NSW GOVERNMENT
Department of Planning

Our ref: MP 08_0222
Your ref:
File: S08/01725

Director General's Requirements for Global Switch Site Redevelopment (MP 08_0222).

Application number	MP 08_0222
Project	Construction of a new 6-storey specialist data centre building with 3 basement levels
Location	273 Pyrmont Road, Ultimo
Proponent	Global Switch Property (Australia) Pty Ltd
Date issued	10/2/09
Expiry date	If the Environmental Assessment (EA) is not exhibited within 2 years after this date, the applicant must consult further with the Director-General in relation to the preparation of the environmental assessment.
Key issues	The EA must address the following key issues: 1. Relevant Environmental Planning Instruments (EPIs) policies and Guidelines to be Addressed: • State Environmental Planning Policy (Major Projects) 2005 • State Environmental Planning Policy (Infrastructure) 2007 • State Environmental Planning Policy No. 55 – Remediation of Contaminated Sites • Sydney Regional Environmental Plan (Sydney Harbour Catchment) 2005 • Sydney Harbour Foreshores & Waterways Area DCP • Darling Harbour Development Plan No.1 • Ultimo Pyrmont Section 94 Contributions Plan, and • The Former

drwg no.
 arskDG01

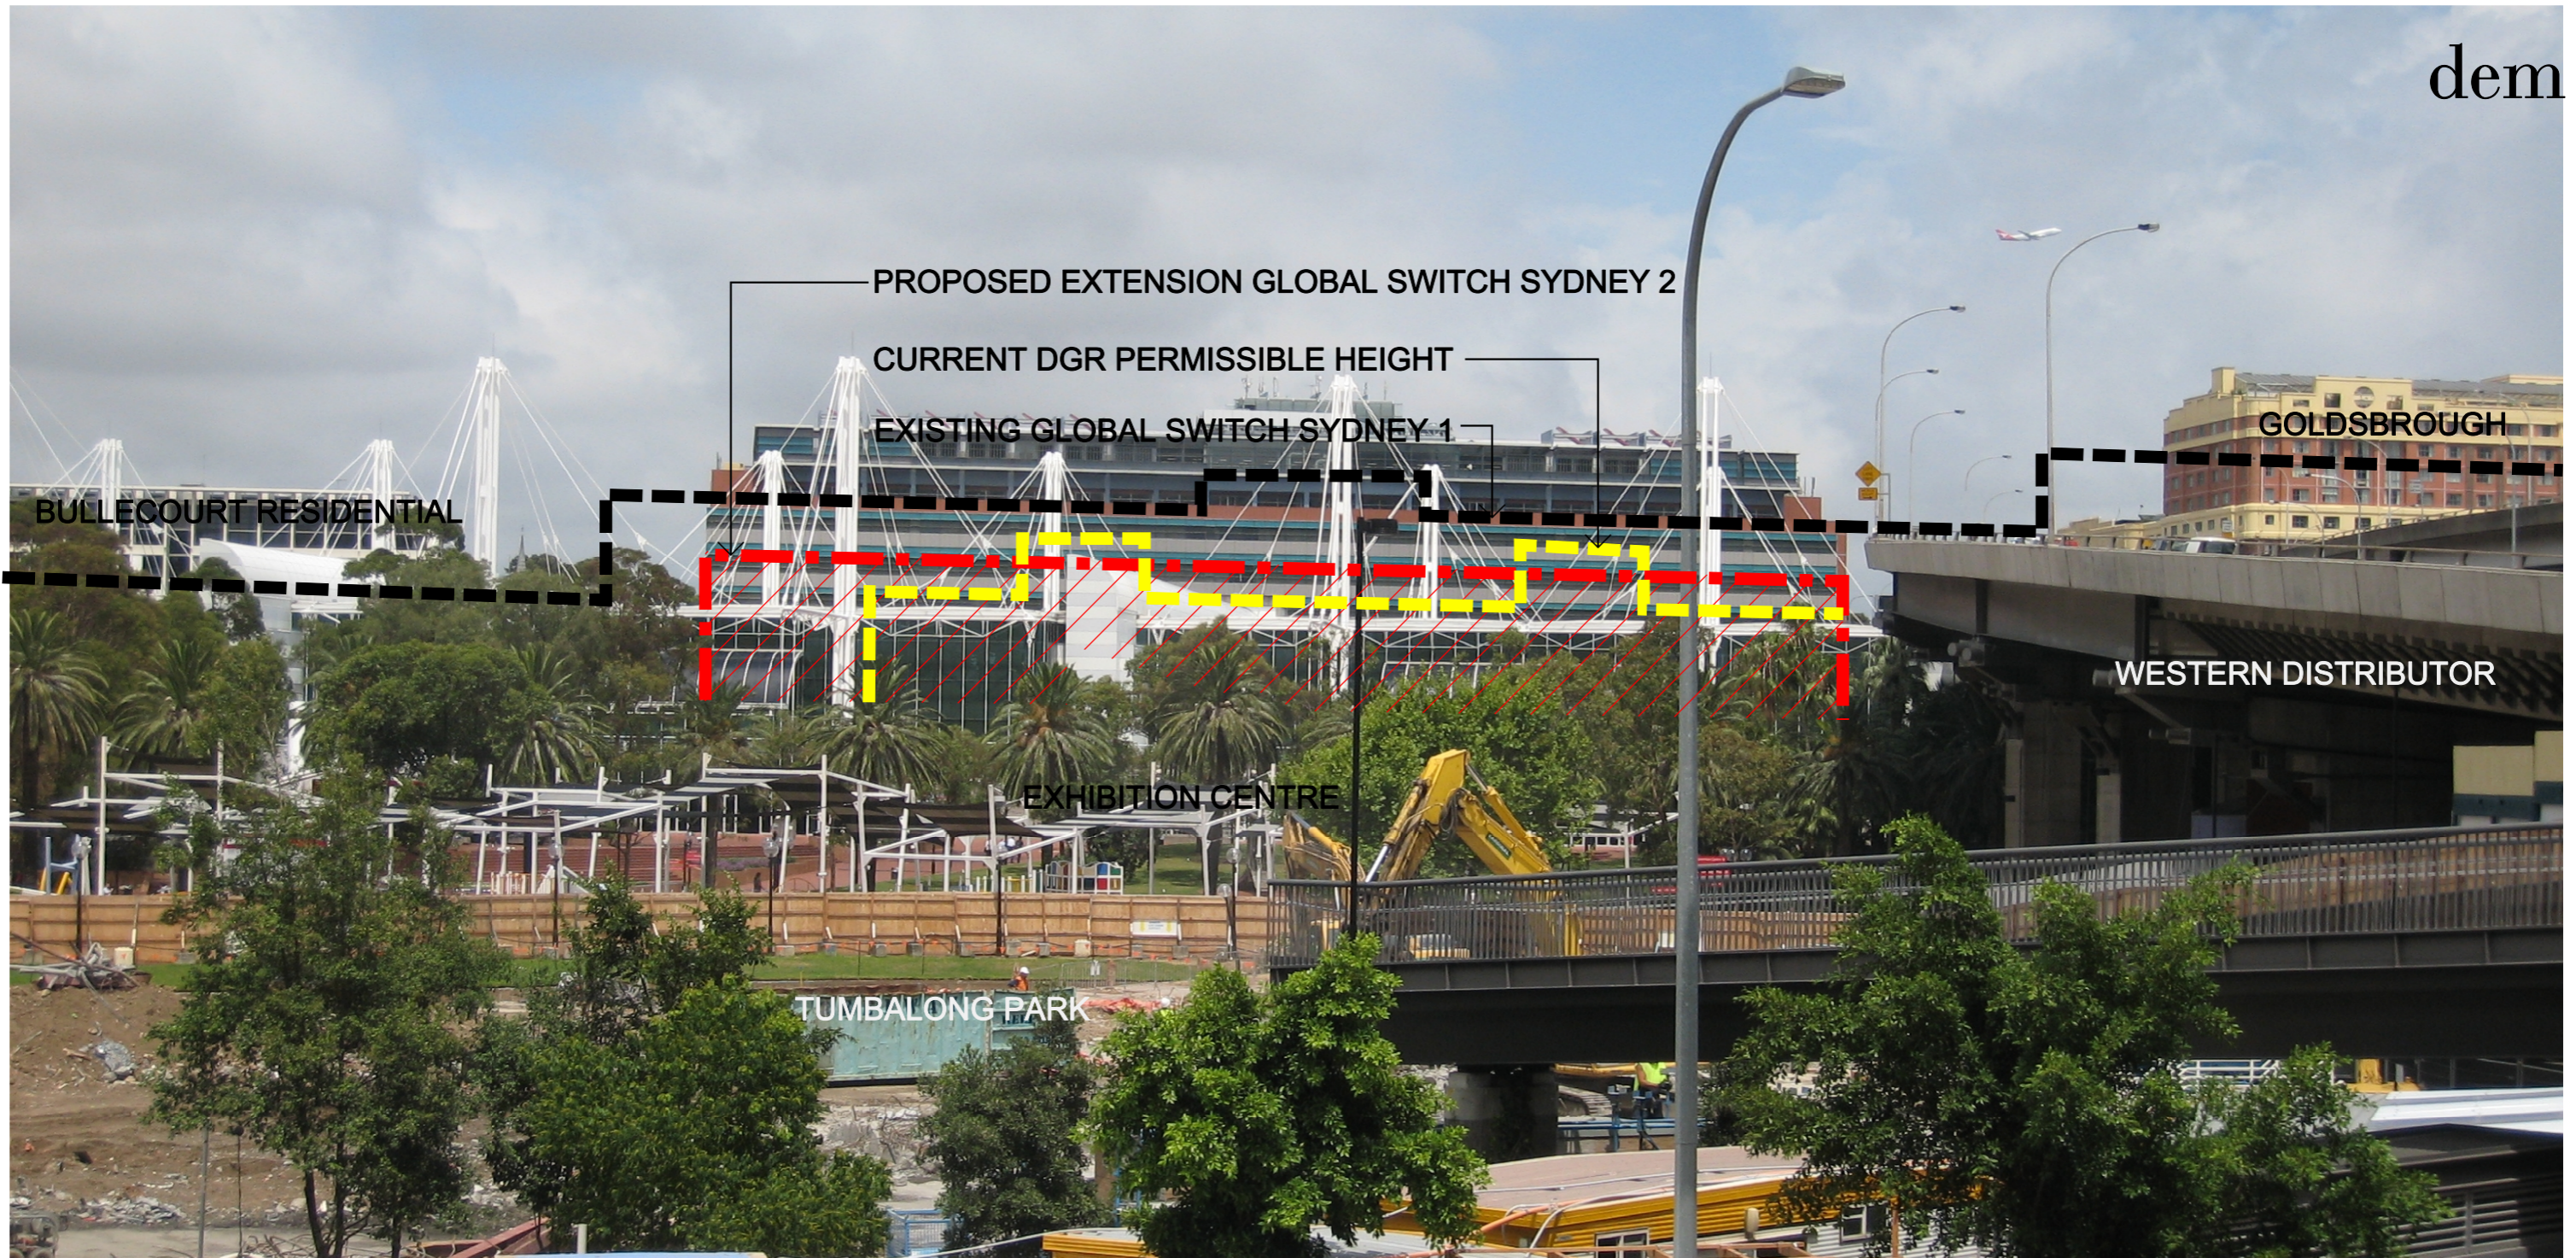
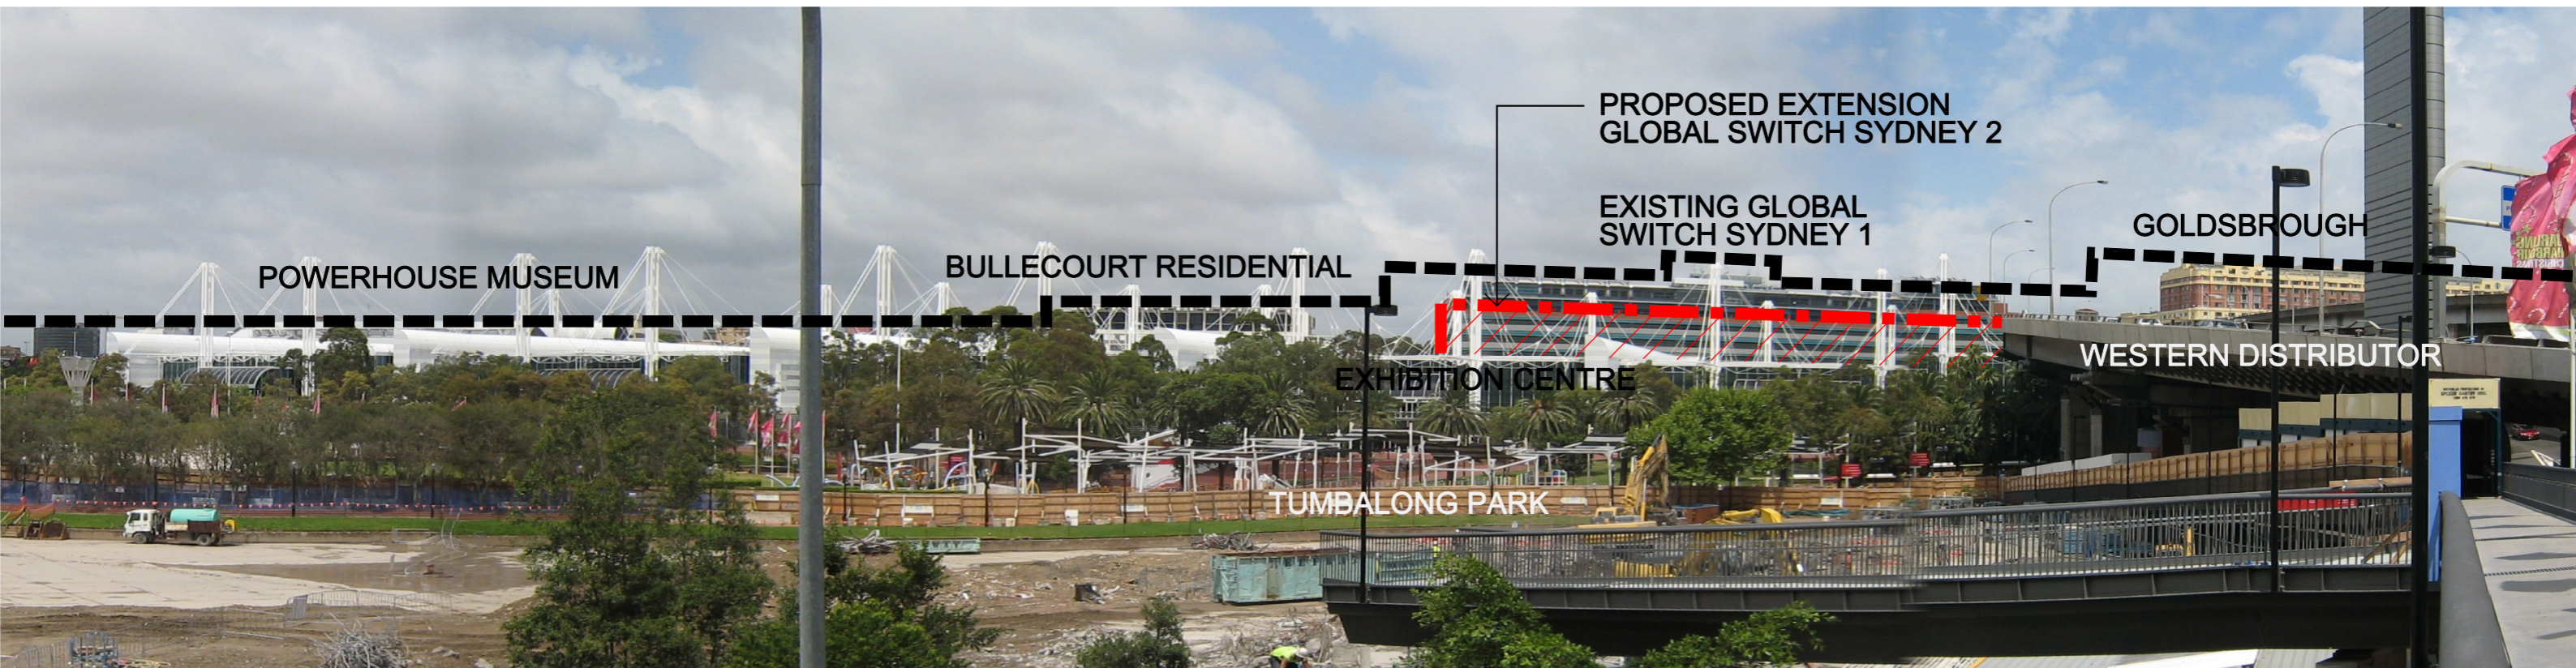
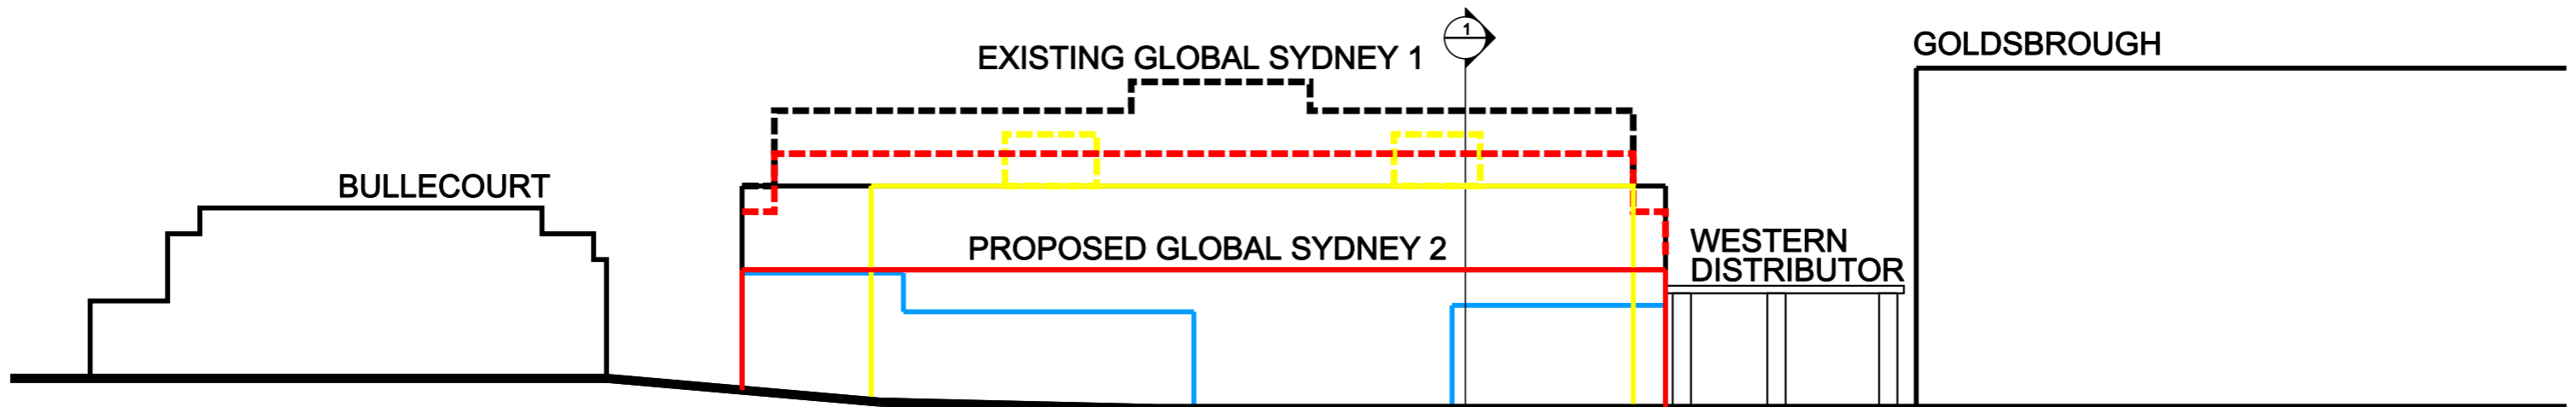
The Department also maintains concern about the height and massing of the building, and its relationship to Goldsbrough Mort, Bullecourt and the existing Global Switch developments. The proposed height of the building exceeds the prescribed height under the Master Plan. The former design for the building achieved greater design articulation, incorporating parapets set back from Pyrmont Street, and an overall lower profile. In accepting that a height greater than that of the current Master Plan may be justified, it was previously determined that any new height should not exceed the original parapet height of the GPO (Global Switch 1) building. It is appreciated that the upper levels would comprise plant areas, but these floors would still contribute to the overall mass of the building and its visual impact.
